MAYBERRY COMMUNITIES

SECTION 14 & 15, IN TOWNSHIP 14 SOUTH, RANGE 63 WEST OF THE 6TH PRINCIPAL MERIDIAN,
EL PASO COUNTY, COLORADO.

SKETCH PLAN

ROADWAY PLAN

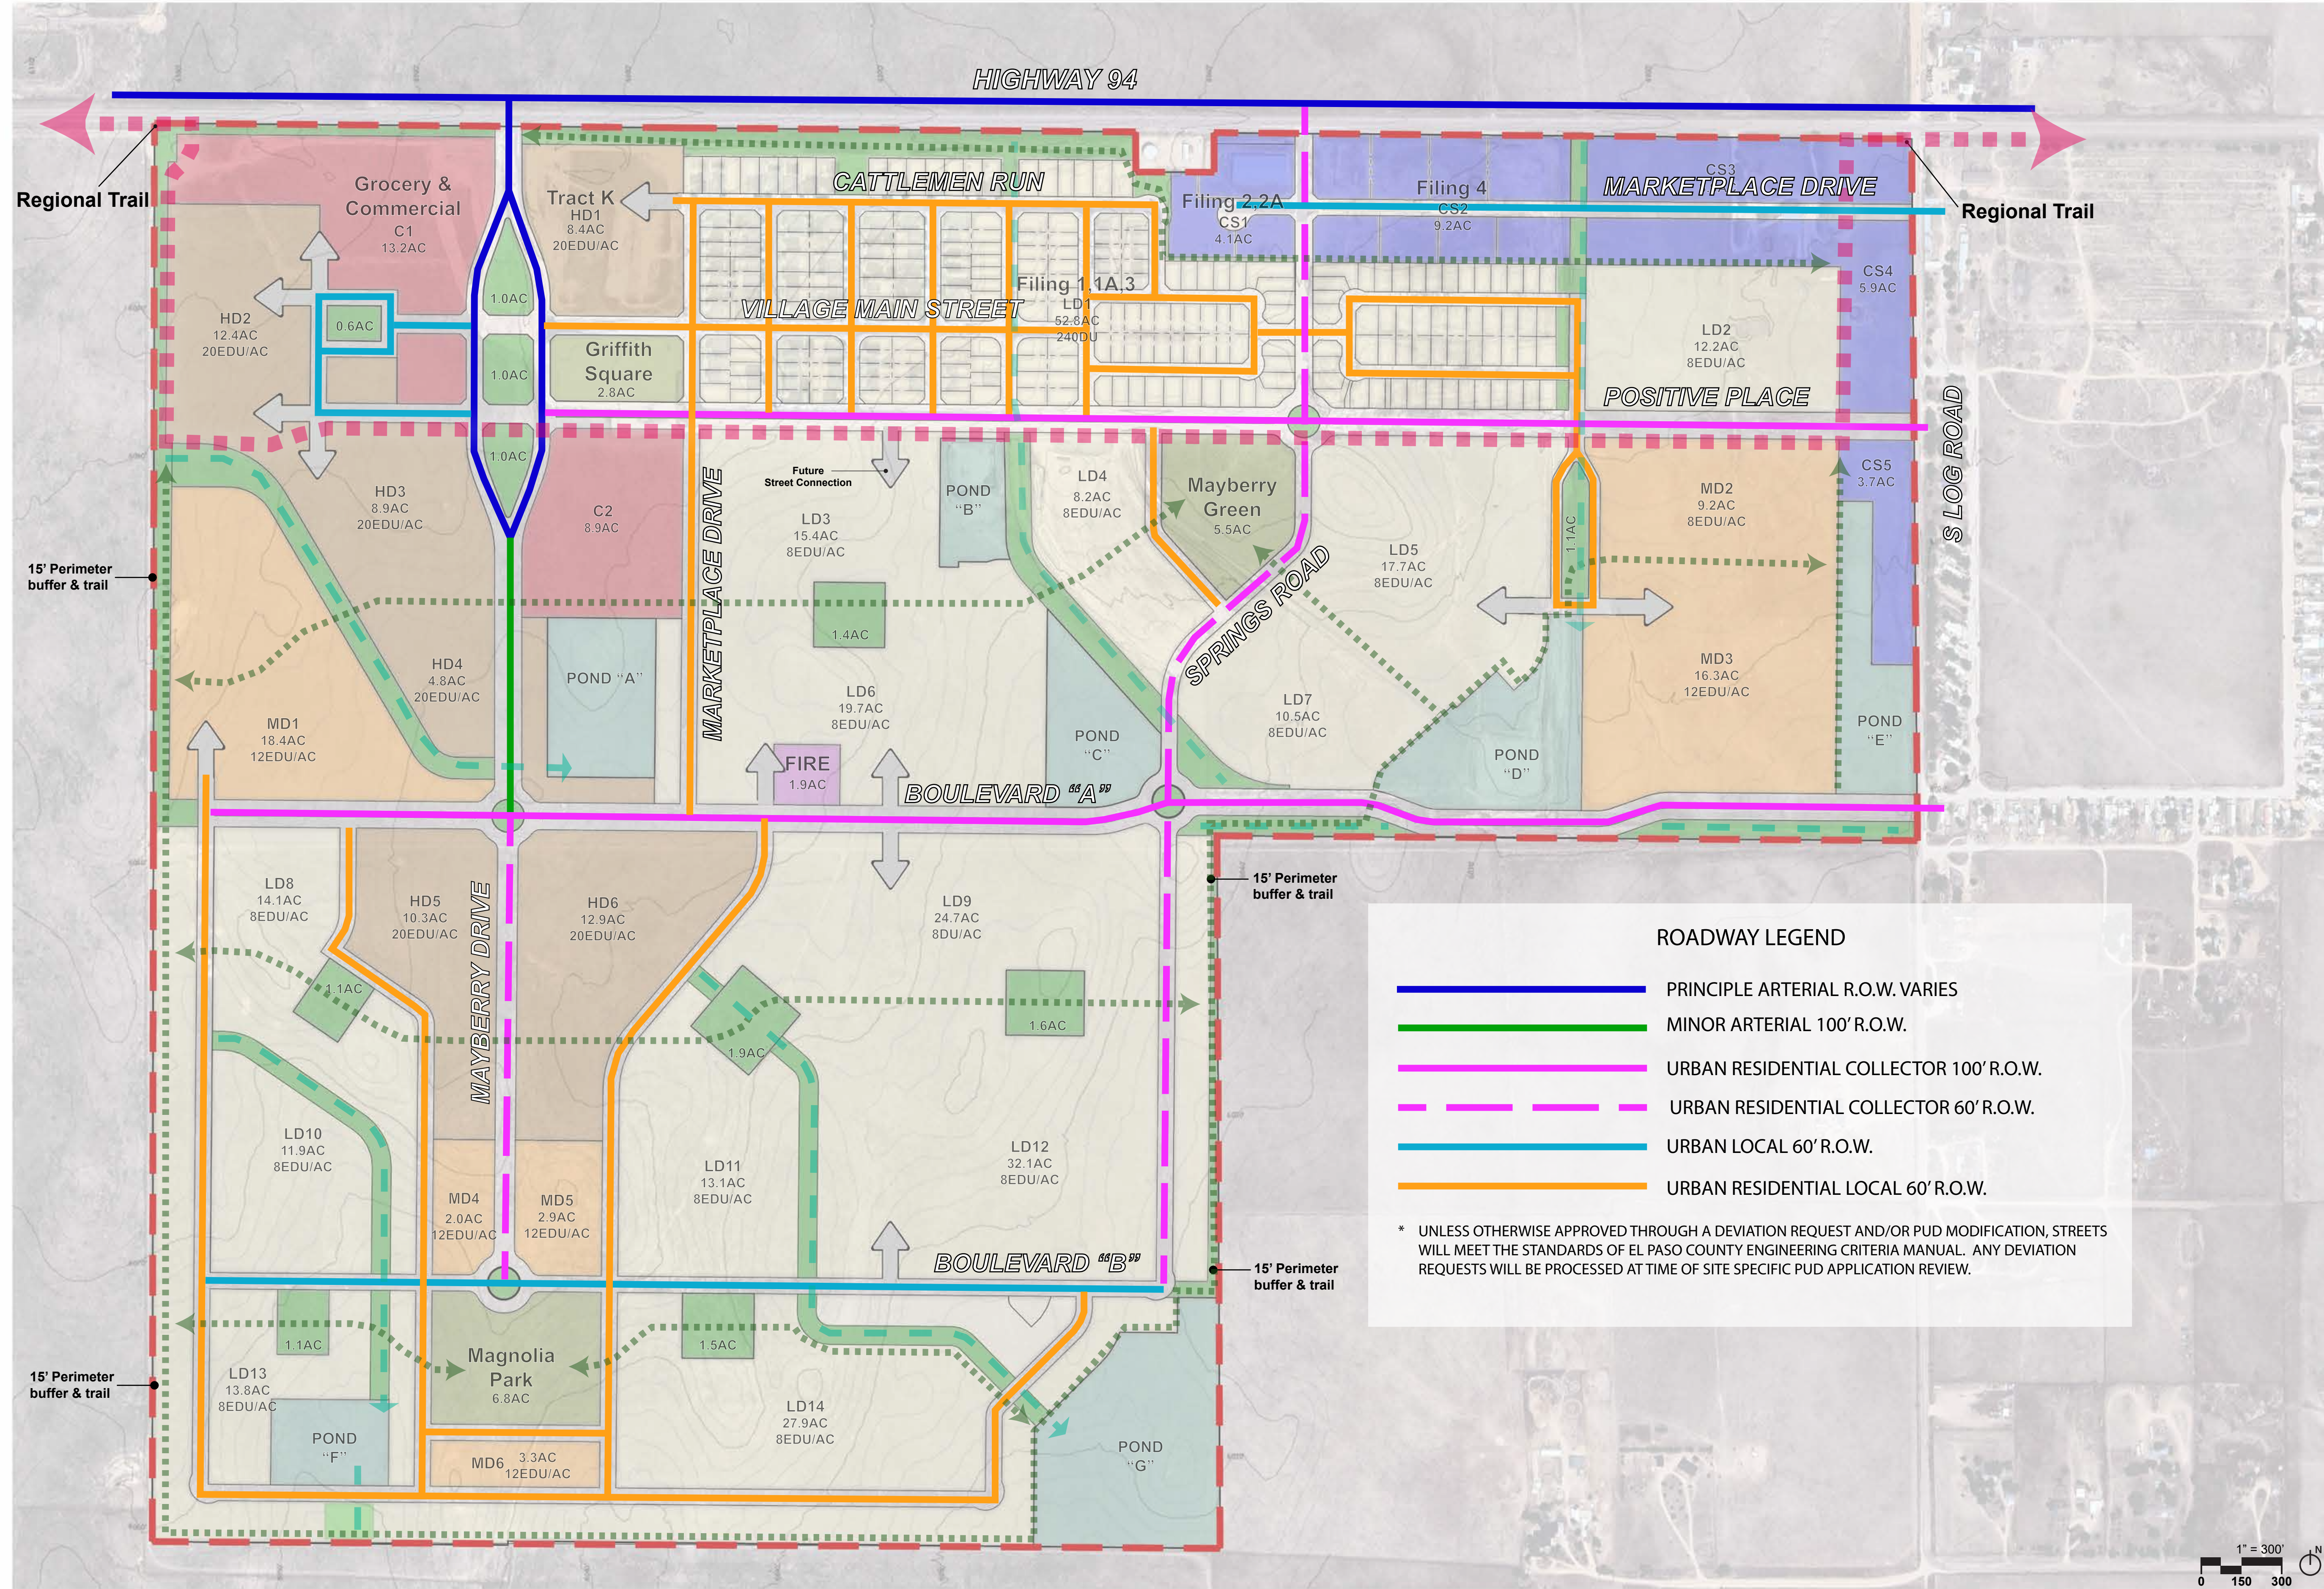
provide classification and ROW width of this road also

The classification of these roadways will be further reviewed once the updated TIS is submitted.

use County ECM nomenclature
